Ribble Valley Borough Council

DELEGATED ITEM FILE REPORT - REFUSAL

Application No:	3/2014/0689/P
Development Proposed:	Demolition of existing derelict barn and erection of two holiday cottages, creation of off street parking and siting of septic tank at land at the junction of Higher Road with Stoneygate Lane, Longridge.

PROPOSED SITE PLAN

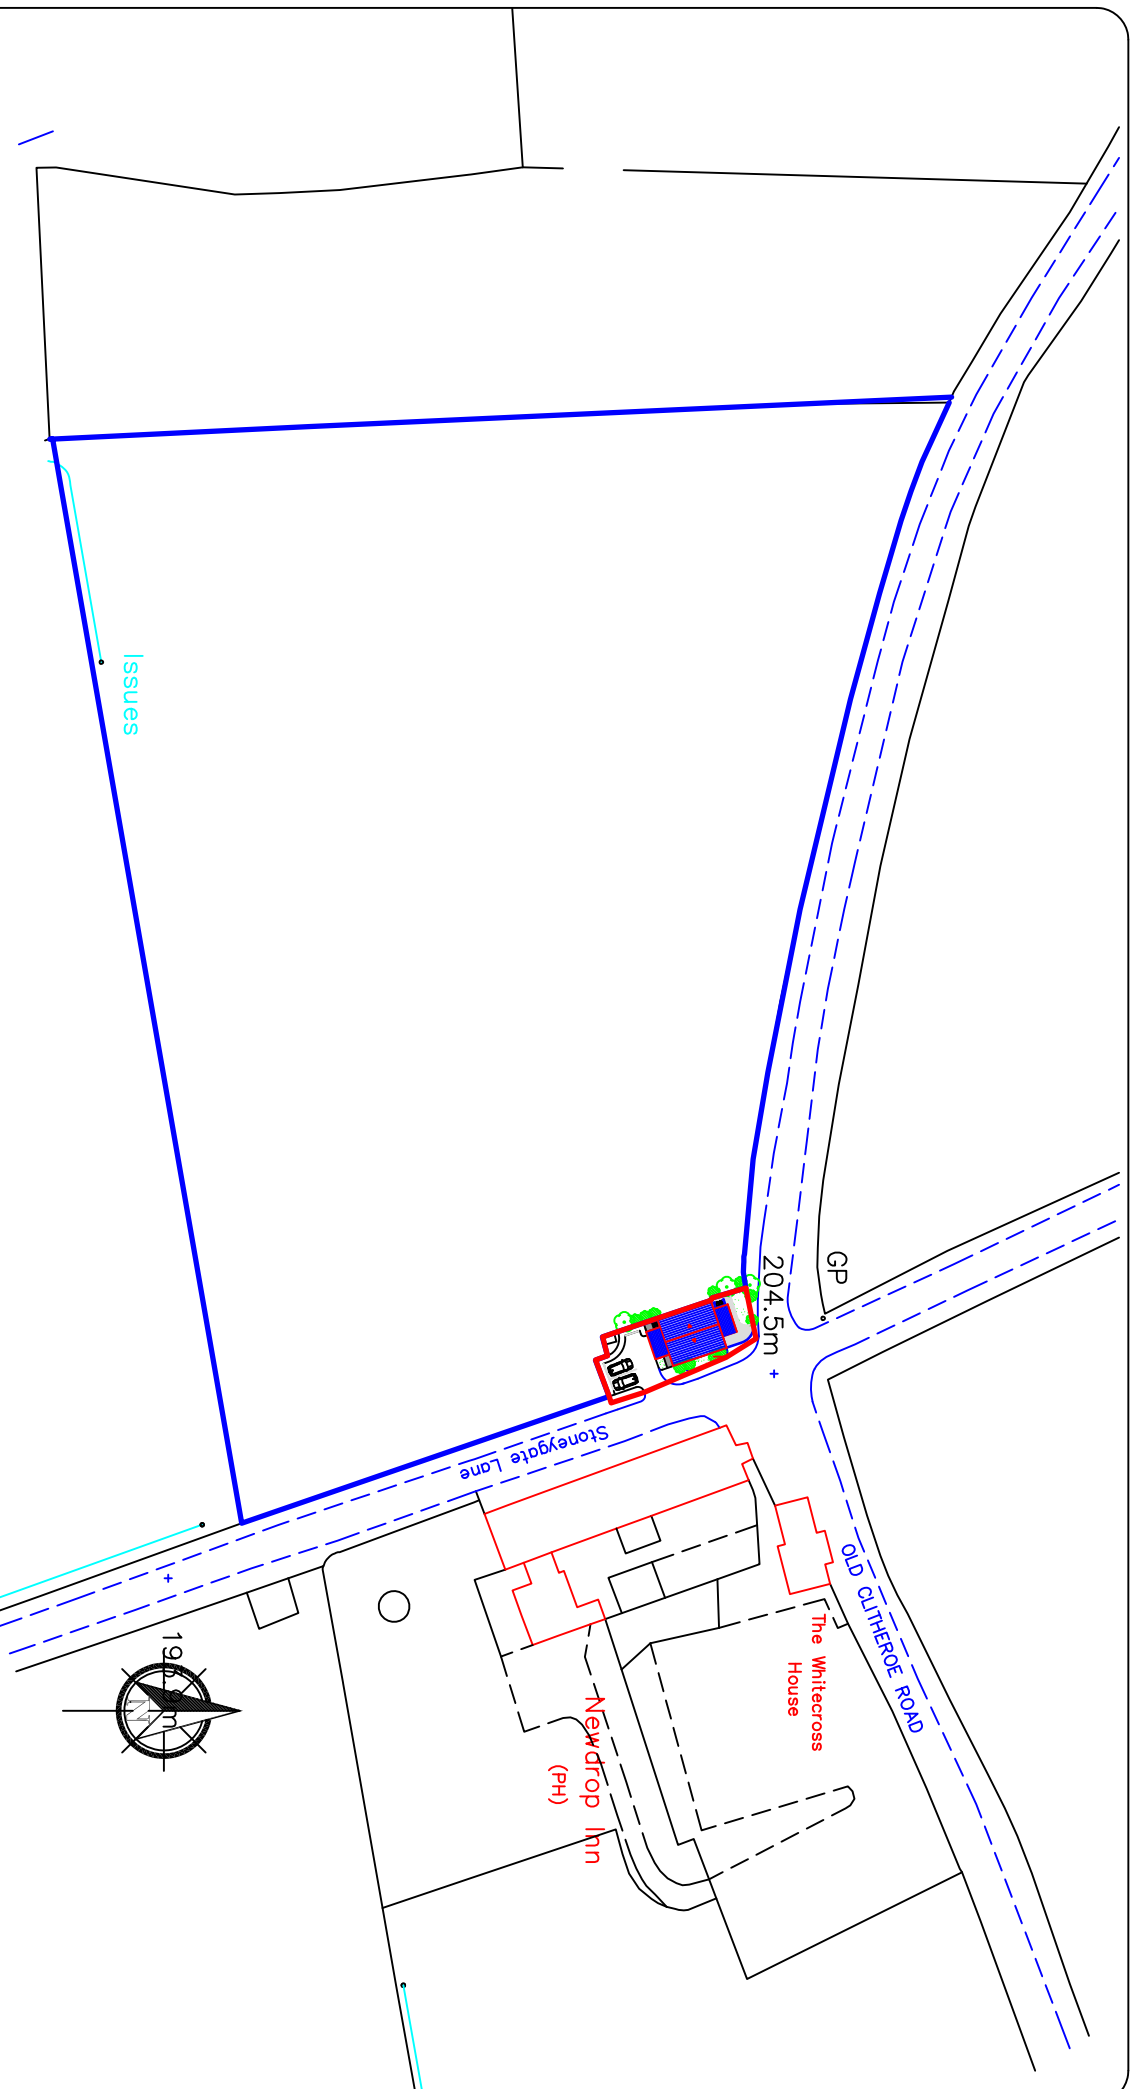
Furthermore, the creation of a car parking area at the southern end of the cottages and an area of curtilage, including hard surfacing, at the northern end would result in the urbanisation of the open countryside in which the proposal would be set. In addition, with no existing site plan submitted it is unclear whether the boundary trees and hedgerow would remain or be replaced. Insufficient information has been submitted to establish if the proposal accords with Policy DME1 of the emerging Core Strategy and Policy ENV13 of the Local Plan which concerns itself with landscape protection and the retention of trees, hedgerows, and other landscape features.

In addition the parking for the property fronting Higher Road is remote from the entrance of the northern most cottage. This would increase the likelihood of parking taking place on the highway/verge close to a crossroad junction. Furthermore, there is no footway link shown along the frontage of the properties which would suggest that any visitors, possibly with luggage etc., would be required to walk in the carriageway.

The proposal would also be detrimental to highway safety, given the inadequacy of the parking provision and the parking provision being remote from the northern most unit, leading to the likelihood of cars being parked on the highway close to a cross roads junction.
